Rosefield Solar Farm (EN010158)

**Rosefield Solar Farm – Buckinghamshire Council's Comments
to the Examining Authority's Written Questions 1**

Buckinghamshire Council

April 2026

Removal of Solar in B6, B7 & B8

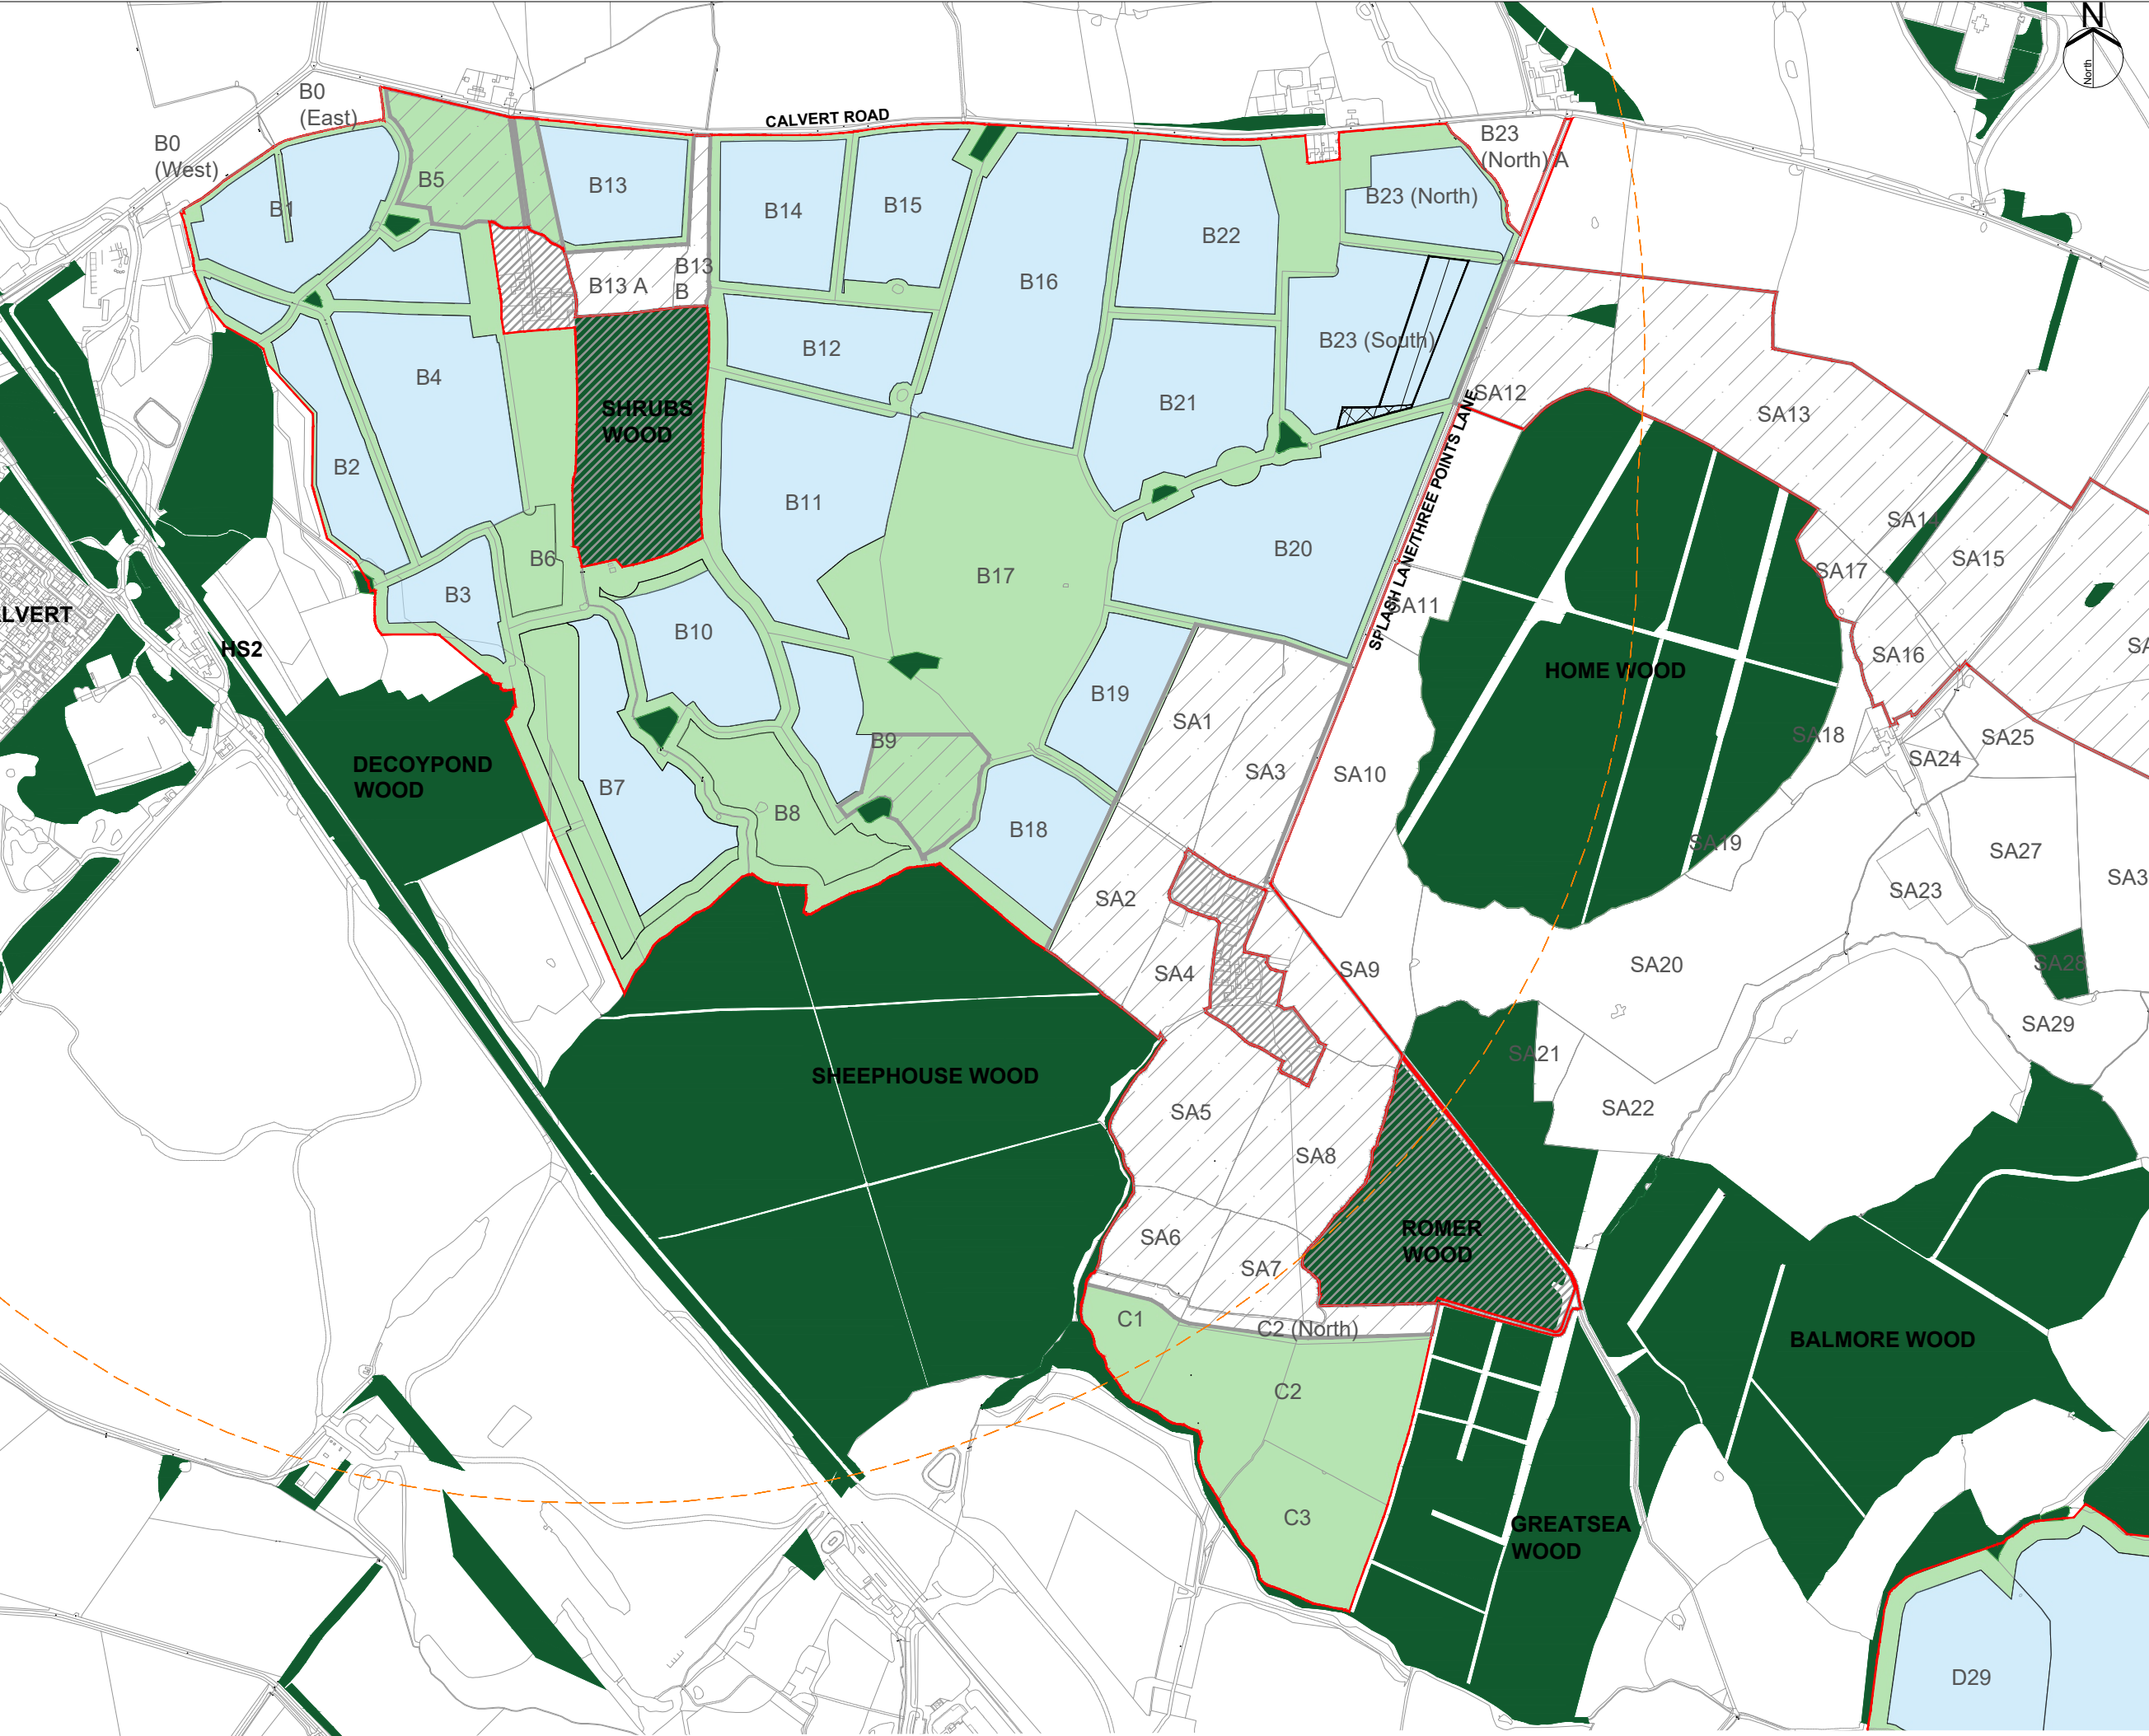
Infrastructure within fields B6, B7, B8, B10, B11 between Shrubs Wood and Sheeppouse Wood SSSI, and fields D28 and D29 between Finemere SSSI and Runts Wood has the greatest potential to result in significant impacts on Bechstein’s bat by

ExQ1	Question to:	Question	Buckinghamshire Council Response
			<p>severing / impacting known existing foraging and commuting routes. The impact could be avoided by the removal of panels and infrastructure from these locations.</p> <p>We require details of the proposed bat monitoring scheme to ensure adequate levels of assessments are implemented to fully inform on the species of concern, Bechstein's Bat. We would expect consistency with the monitoring programme for HS2 ensuring ensure cumulative impacts of both schemes are fully considered. Discussion with Natural England will be required due to the Licencing requirements for this level of monitoring.</p>
Q1.7.7	The applicant	<p>Environmental Improvement Plan 2023 and Local Nature Recovery Strategy for Buckinghamshire and Milton Keynes</p> <p>Buckinghamshire Council suggests [REP1-112] that the potentially significant effects identified on Bechstein's bats appear to contravene goal 1 of the Environmental Improvement Plan 2023 that the proposed development would result in fragmentation of an existing established ecological network, which goes against government's national policies and strategies for nature recovery.</p> <p>1. Do you agree with these statements? If not, why not?</p> <p>If the effects on Bechstein's bats were determined to be significant (rather than potentially significant) do you consider that this would result in conflict with the aims of the Environmental Improvement Plan 2023 or Local Nature Recovery Strategy for Buckinghamshire and Milton Keynes?</p>	<p>Bechstein's bat are a Key Species identified within the Local Nature Recovery Strategy. The site is within a Target Area for Species Recovery; Grendon Greatmoor. Where the target is to 'Expand SSSI areas and manage areas linking primary sites for biodiversity; particularly bats, old trees, various neutral grasslands and damper areas. See also Shortlist Species/assemblage measures Duke of Burgundy Fritillary butterfly, Blackthorn Butterflies and Moths'</p> <p>The Council would consider a scheme which had a significant impact on Bechstein's bats to be at conflict with the aims of the Local Nature Recovery Strategy for Buckinghamshire and Milton Keynes.</p>
